Sanctuary of Peace Cohousing Community at Benet Hill, PUDSP-19-002
(Revised Comments)

Please accept the following comments from El Paso County Public Health (EPCPH) regarding the 49.58-acre, 27-commercial/residential lot development project referenced above:

Mike McCarthy
El Paso County Public Health
719.575.8602
mikemccarthy@elpasoco.com
27Jan2020

DP-4 MVE PROJECT 61087
MVE DRAWING DEV-PG

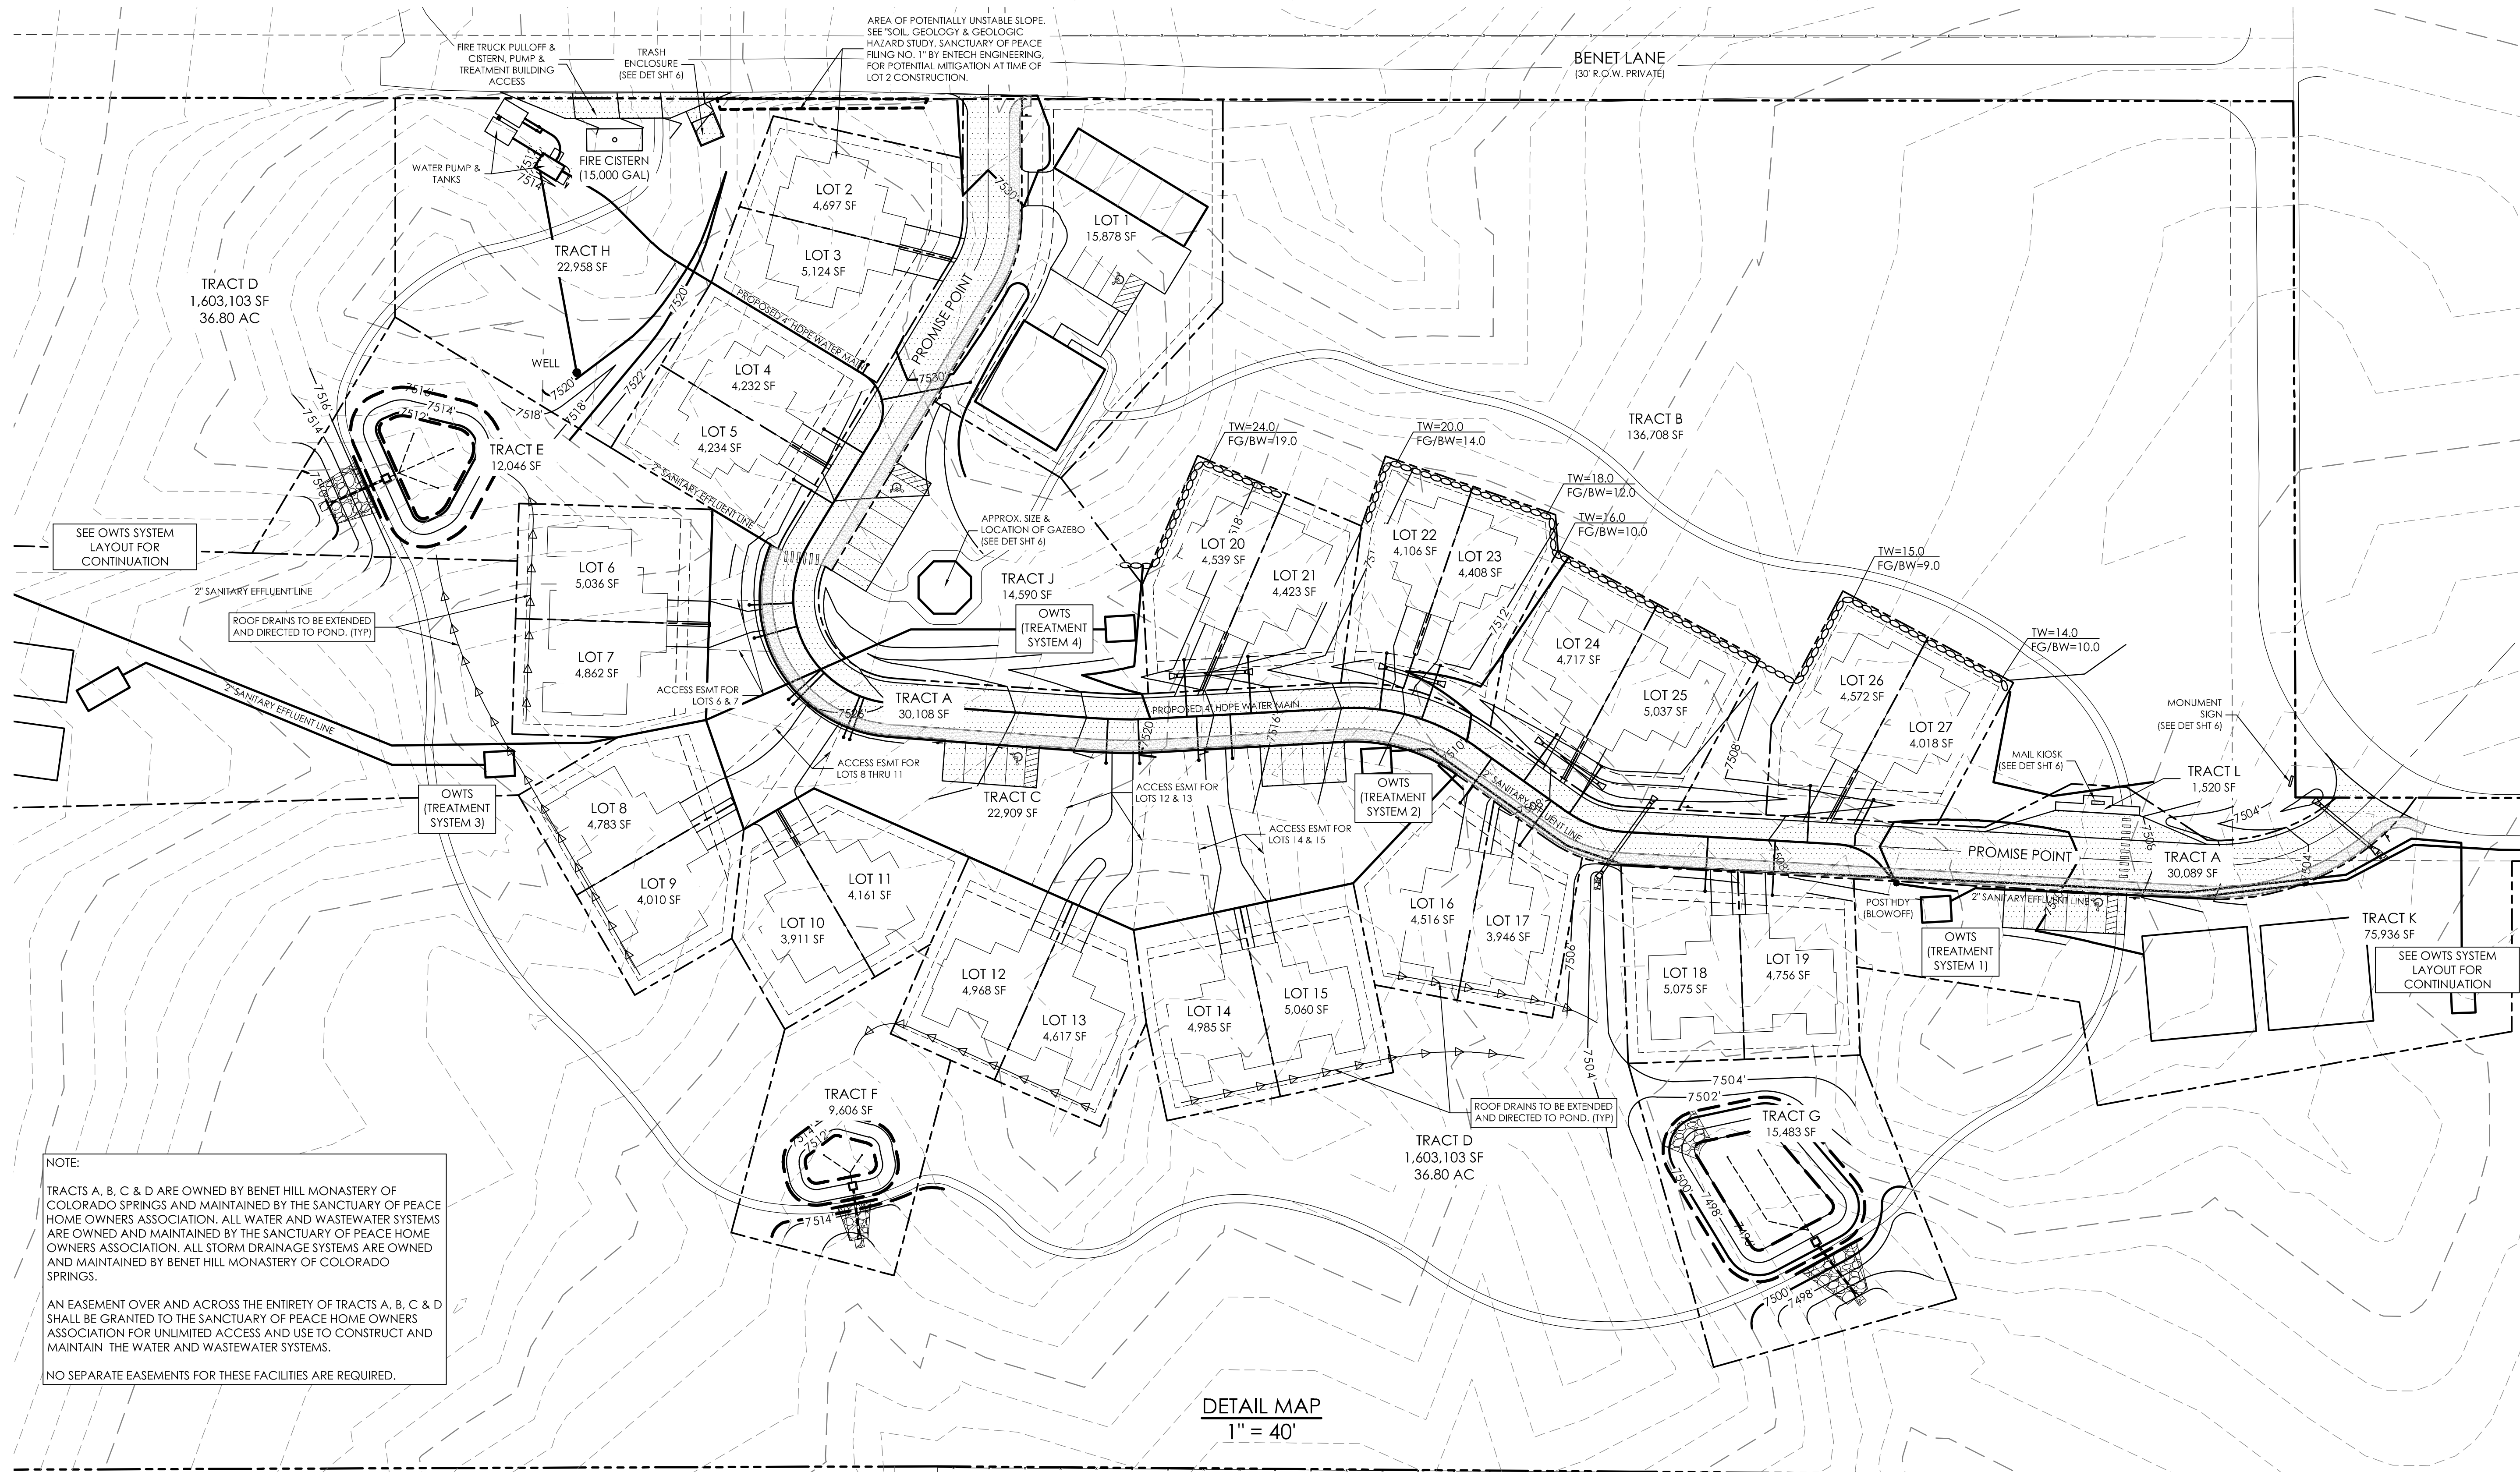
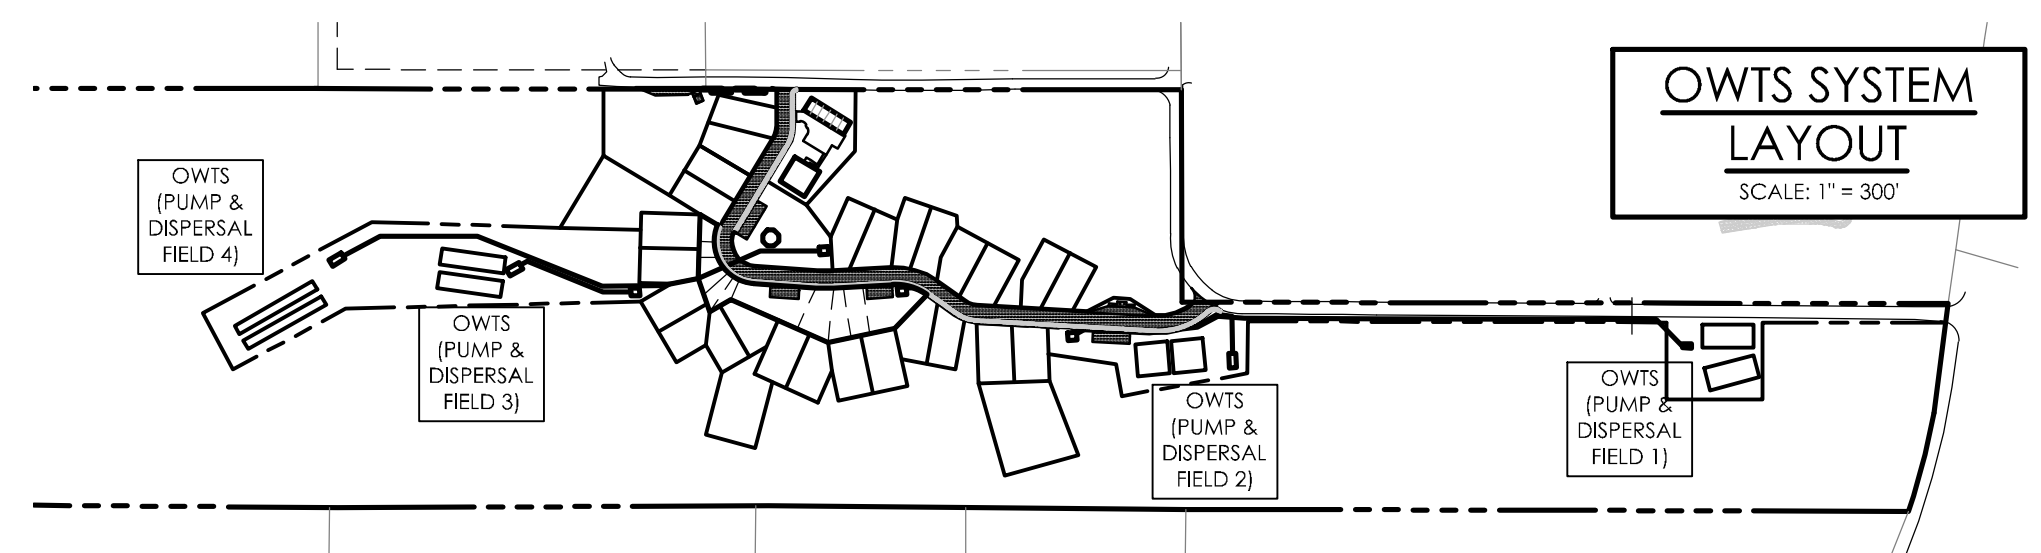
- Wastewater treatment for the development is proposed to be by high-level treatment, onsite wastewater treatment systems (OWTS) and Water Quality Policy #6 established by the WQCD for locating multiple systems on one lot. A 12Sept2019 OWTS – Site Evaluation for Sanctuary of Peace, Filing No. 1, Project No. 61087 Report, submitted by MVE, Inc., and a 285 Engineering OWTS Design Report dated 18June2018, were reviewed that explain the wastewater plan in detail. Details included in the report are:

- The clustered lots layout for the proposed 26-residential lots and 1-community club house lot with 4-bedrooms.
 - The well and OWTS locations and the corresponding zones of influencing mapping showing how minimum setbacks from various OWTS and water system components will be maintained.

- Each of the 4 OWTS's proposed require a new OWTS Permit from El Paso County Public Health.
- Earthmoving activity in excess of one acre, but less than twenty-five acres, requires a local Construction Activity Permit from El Paso County Public Health. Go to <https://www.elpasocountyhealth.org/service/air-quality/construction-activity-application> for more information. Earthmoving activities greater than 25 acres require a Construction Activity Permit from the Colorado Department of Public Health and Environment, Air Pollution Control Division. Go to: <https://www.colorado.gov/pacific/cdphe/general-air-permits>
